Item No. **Report of the Interim Director of Planning, Regeneration & Public Realm**

Address: 14 DEVON WAY HILLINGDON

Development: Change of use from C4 house in multiple occupancy (HMO) to sui generis HMO for 7 bed and 7 persons with no external alterations.

LBH Ref Nos: 27994/APP/2021/3581

SITE PLAN (1:500)

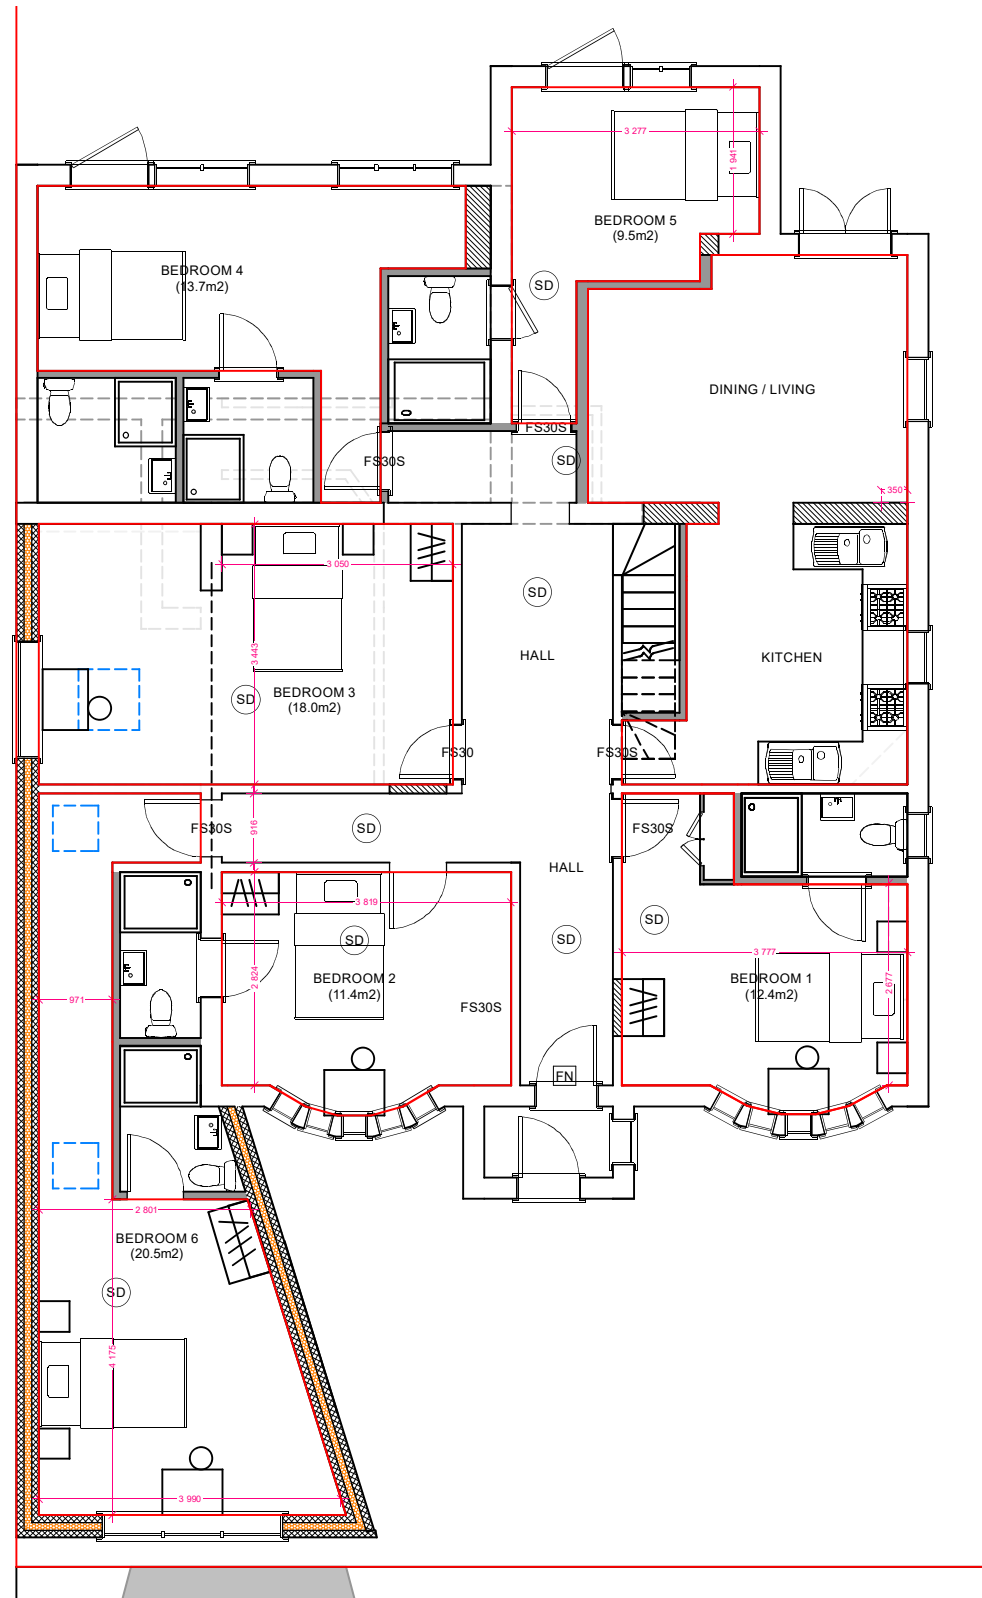
- Submitted plans are incorrect as there is not four on-site car parking spaces (in reality there is only

The application site benefits from a front forecourt that can accommodate 2 vehicles. On-street parking in the vicinity of the site is regulated through single yellow lines a residents' parking permit scheme (HN1). Due regard has been given to the former use of the property as small HMO accommodating up to six persons. However, in the absence of a signed legal agreement to prohibit occupiers from obtaining street parking permits, it is considered that the existing large HMO accommodation coupled with the self-contained residential unit within the outbuilding, would likely park their vehicles on the nearby roads. The site has a PTAL rating of 2 (Poor) which means its likely that occupiers of the site would be reliant on private vehicles as a means of transport. Thereby, exacerbating the pressure for street parking. A parking impact assessment has not been submitted to demonstrate that the street parking spaces on nearby surrounding roads has sufficient capacity to accommodate the additional parking demand generated by the development. Thus, leading to increased instances of dangerous or illegal parking. This in turn, would result in congestion and prejudice highway safety.

PROPOSED G/F (1:100)

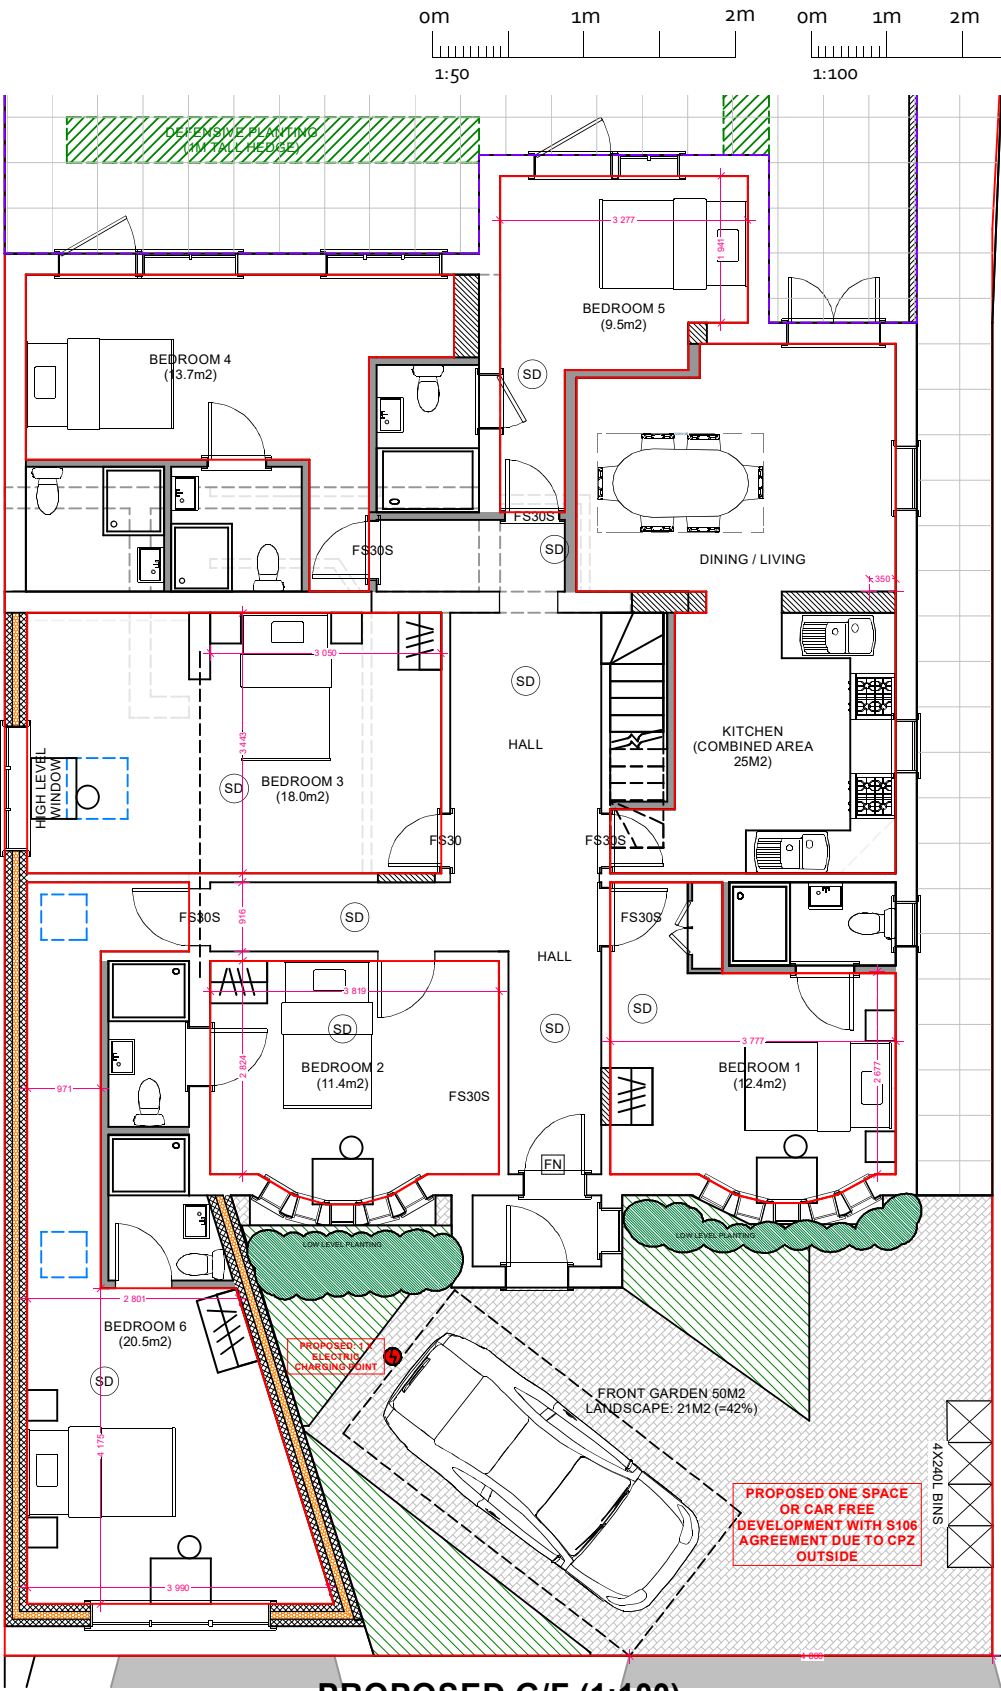
Each of the 7 HMO of the bedrooms benefits from their own en-suite shower rooms and a kitchen cabinet with no sink. During the officer site visit it was observed that none of the 7 rooms contain any cooking facilities (or microwaves). The submitted plans shows a communal kitchen and dining room area on ground floor level, and this was confirmed during the site visit. Having regard to the 'Gravesham' Court Judgement, it is considered that the rooms do not constitute as a self-contained units and that the use of the main property is a large HMO (Sui Generis).

It is acknowledged that the Hillingdon Local Plan: Part 2 - Development Management Policies (2020) does not contain any specific standards in respect to HMO. The submitted plans shows that the seven bedrooms which are each occupied by a single person range between 9.5 sqm and 20.5 sqm, which is considered to be acceptable when compared to the bedroom standards prescribed in parts 3 and 4 of Policy D6 of the London Plan. The kitchen/dining/living room has a floor area of 25 sqm which is considered to be of a sufficient size to meet the needs of the seven occupants.

Although Bedrooms 3 and 7 have limited outlook, this is considered, on balance, to be acceptable having regard to the former use of the property as a small HMO. Similarly, the relationship between the windows serving Bedrooms 4 and 5 and the communal garden would not be significantly different to former use of the property as a small HMO. With an area of 135 sqm, the communal rear garden for the occupiers of the HMO is considered to provide an adequate provision of external amenity space.

ANNEX - R/O 14 DEVON WAY

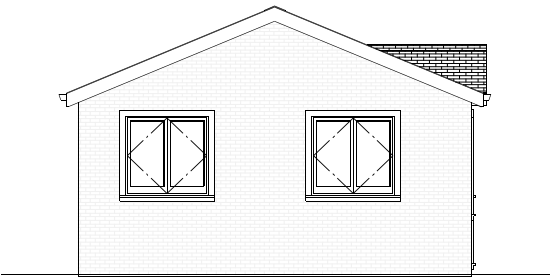
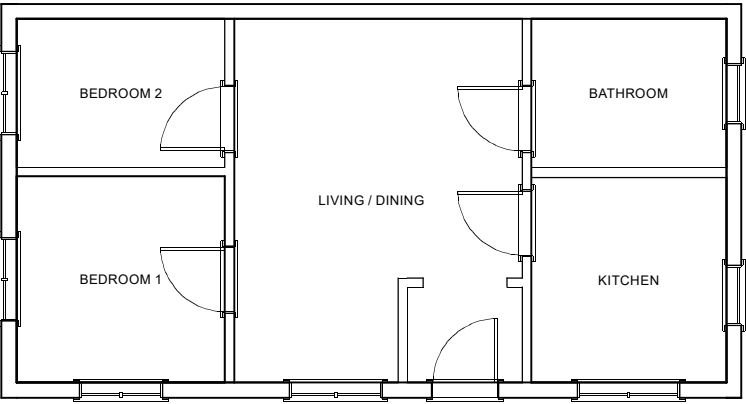
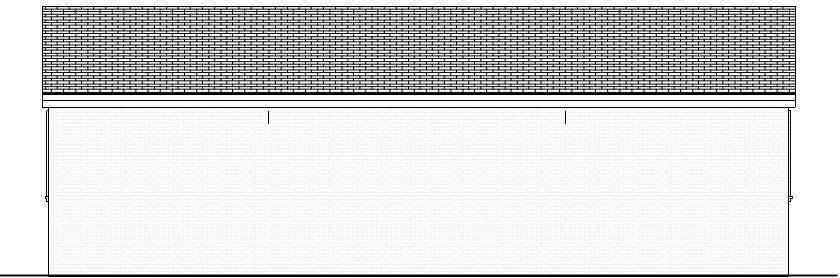
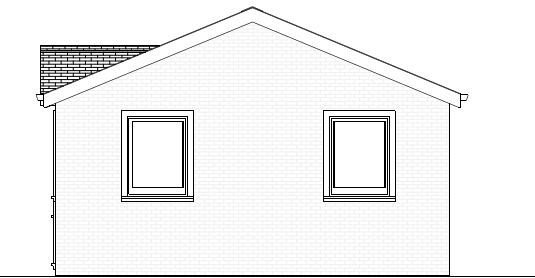
In this case, the existing brick built outbuilding at the site contains a kitchen with a sink, oven and stove; an open plan living/dining room; a shower room with a toilet and hand basin; and two bedrooms. It is therefore considered that the outbuilding has all the day-to-day facilities for it to be used as a self-contained residential unit. There is independent access to the outbuilding through the side passageway. Furthermore, the outbuilding has been sectioned off from the main property by the erection of timber fencing running along its front elevation. Given these circumstances, it is considered that the outbuilding is a self-contained residential unit and as such a separate planning unit has been created.

Based on planning records, it does not appear that the height or footprint of the brick built outbuilding is different to the former wooden outbuilding. Therefore, the physical structure of the outbuilding has not resulted in a loss of light for neighbouring occupiers.

The outbuilding to the rear of the site has been constructed in brickwork and contains uPVC windows. It has been sectioned off from the main property by fencing. The use of the end of the garden as a separate residential planning unit is an alien form of backland development. It does not reflect the established pattern of development in the local area, which comprises single and two storey dwellings fronting the street.

The rear outbuilding has a gross internal area of 45 square metres, which falls significantly below the London Plan's minimum 61 sqm requirement for a 2 bedroom, 3 person dwelling. Given the figures in Table 3.1 of the London Plan are minimum standards which are intended to act as a benchmark for high quality design, the shortfall in the internal floor space provision is not appropriate. The front elevation habitable windows face directly towards fencing measuring 1.8metres, which is positioned 1 metre away. The side windows serving the bedrooms within the outbuilding face directly towards the side boundary treatment. It is therefore considered that outbuilding provides unsatisfactory living conditions for its occupiers, in terms of inadequate floor space and poor outlook. It cannot be argued that the existing fencing could be removed as this would give rise to a loss of privacy and overlooking issues between the occupiers of the outbuilding and HMO (which contains habitable windows within its rear elevations)

There is a small section of hardstanding adjacent to the northern flank wall of the outbuilding. However, this area is not considered to constitute as private useable amenity space as its covered in hardstanding and adjoins the side passageway leading to the rear garden of the HMO. Consequently, the outbuilding has no external amenity space provision, which conflicts with the minimum 60 square metre requirement found in Table 5.3 of the Hillingdon Local Plan (Part 2).
